Application for a non-material amendment following a grant of planning permission.

Erection of 12 no. four-bed, three-storey dwelling houses (Class C3) with associated parking, landscaping and boundary treatment following demolition of existing, vacant, public house

Reference number:	<input type="text" value="123559/JO/2019"/>
Date of decision	<input type="text" value="14/08/2019"/>

Amendments to soft and hard landscaping in relation to statutory and/or utility company requirements.

PROJECT	BURTON ROAD		
DRAWING	SITE PLAN - LANDSCAPE/BOUNDARY SETTING OUT		
DATE	NOV. 20	DRAWN BY	KV SCALE 1:100 @ A1
JOB NO.	1403	DWG. NO.	L1006 - REV B

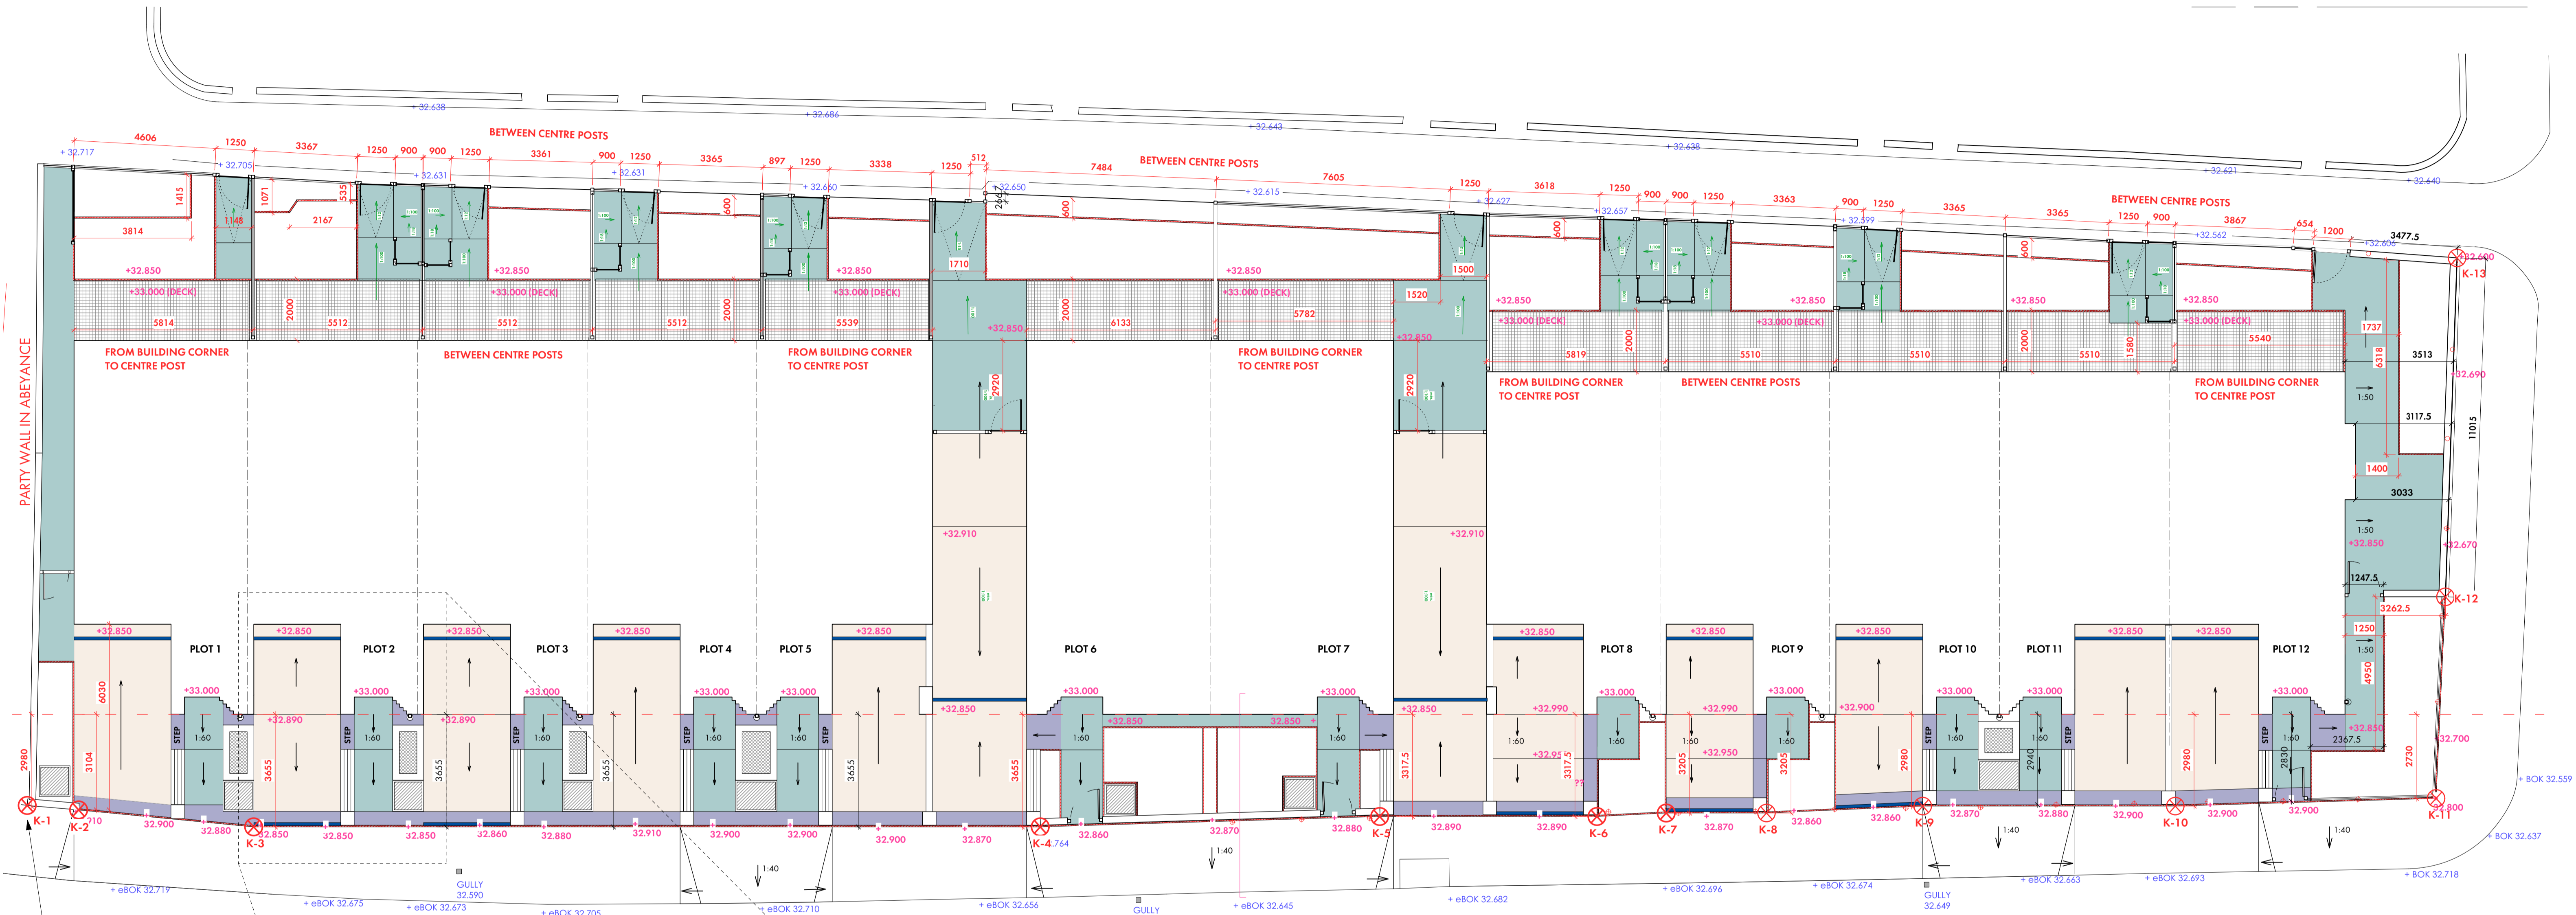
**2. Removal of stepped access to front entrances**

The steps, and associated tactile paving, on the approved plans have been omitted to the front curtilages of plots 1-6 and replaced with ramped access

2. The approved proposal allowed for the driveways of plots 1-6 to be used as the accessible front entrance with stepped access as the main pedestrian access. This is due to topographic site levels gained prior to development.

Building Control confirmed on site that they would prefer that the external steps be replaced with ramped entrances.

Upon review of site levels following the erection of the dwellings and simultaneous to new pavement works, it was found that ramped access of low gradient could be achieved across all properties. The tactile paving associated with the steps would not be required and such has been omitted along with the steps in the site plan

PROJECT	BURTON ROAD				
DRAWING	EXTERNAL WORKS SECTION 1				
DATE	NOV. '20	DRAWN BY	KV	SCALE	1:20 @ A3
JOB NO.	1403	DWG. NO.	A2501 - A

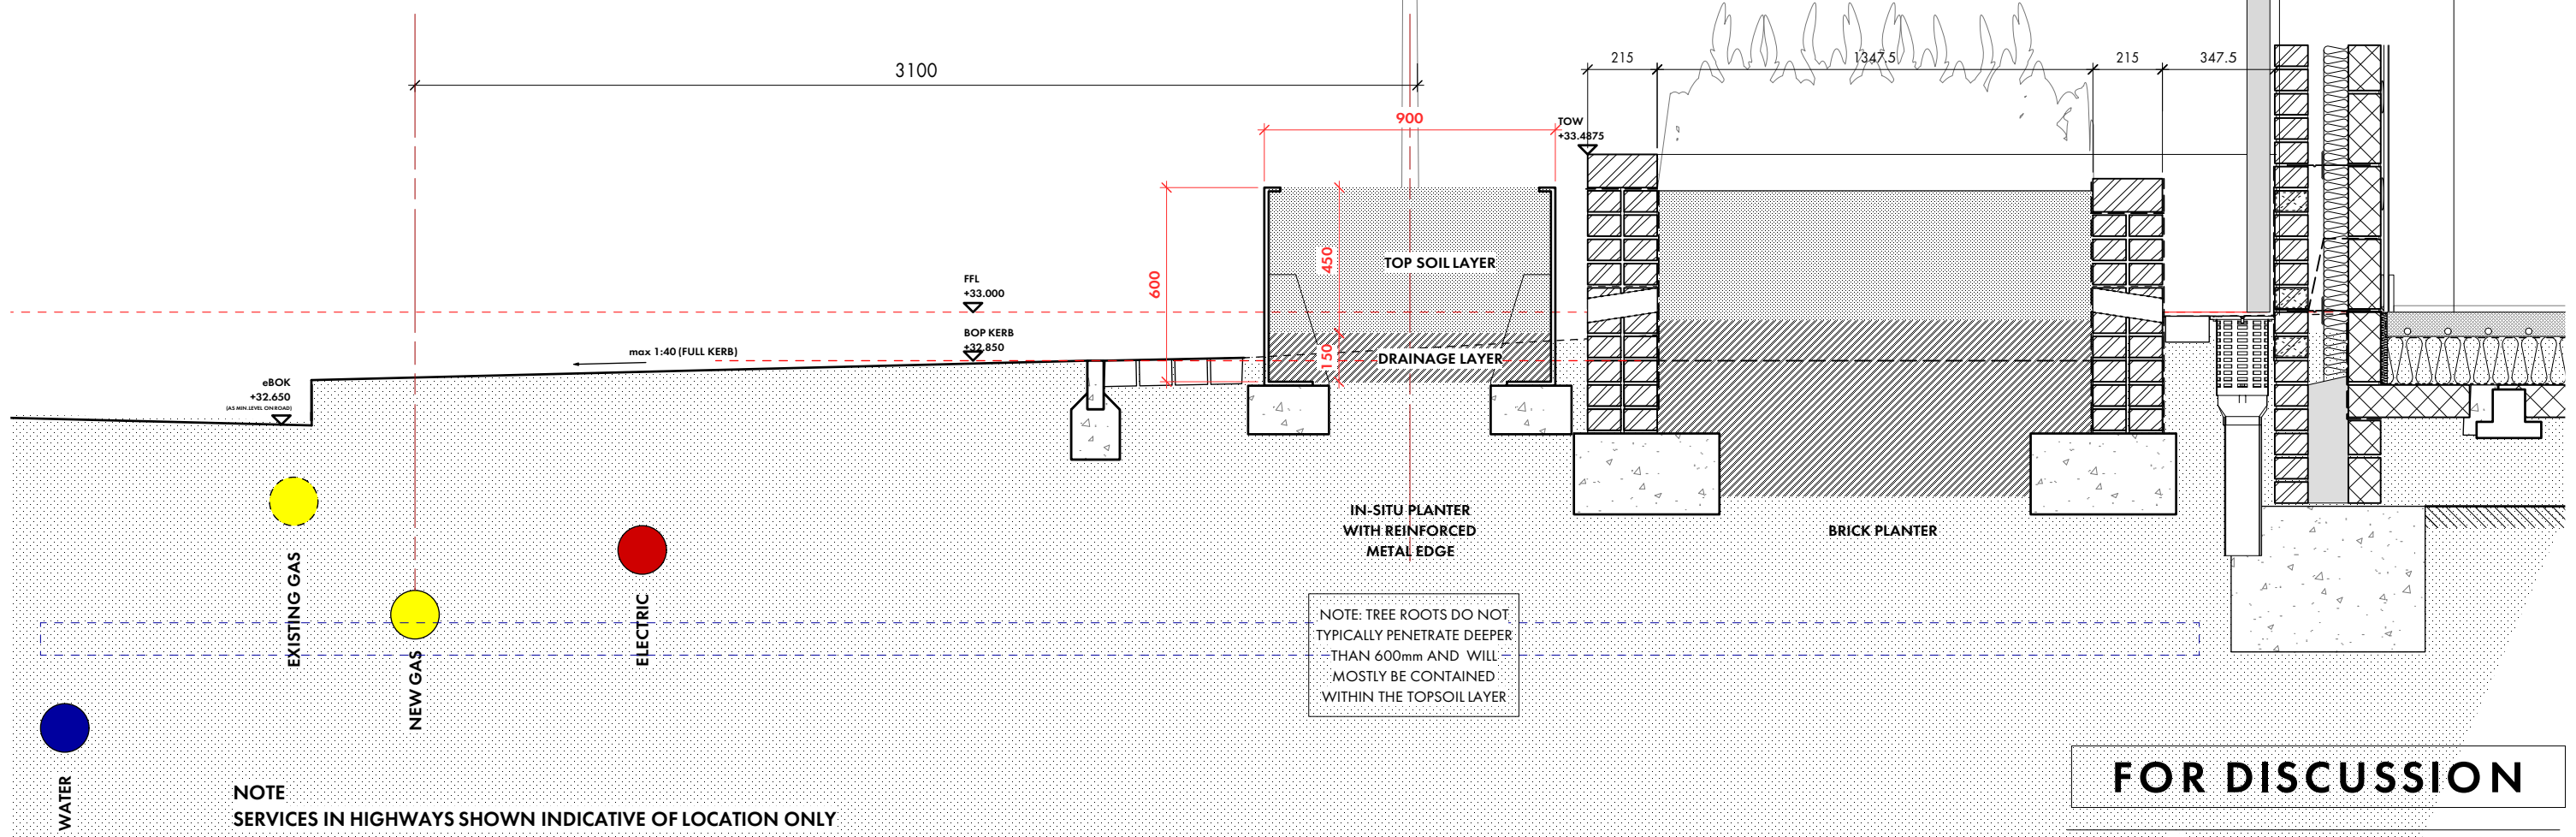
**1. Tree planters along Burton Road**

The tree pits proposed at ground level are to be replaced with raised planters formed from a metal edge, installed in situ on concrete pads. The species of tree has been changed to suit the raised planters

1. Concern from Cadent, gas utility company, over the proximity of trees to existing and new gas mains along Burton Road has caused us to pursue alternative solutions whilst maintaining the desired street scene with permanent and high-quality planting. The open-based planter will sit 600mm above ground level, mitigating the concern over roots penetrating any utilities.
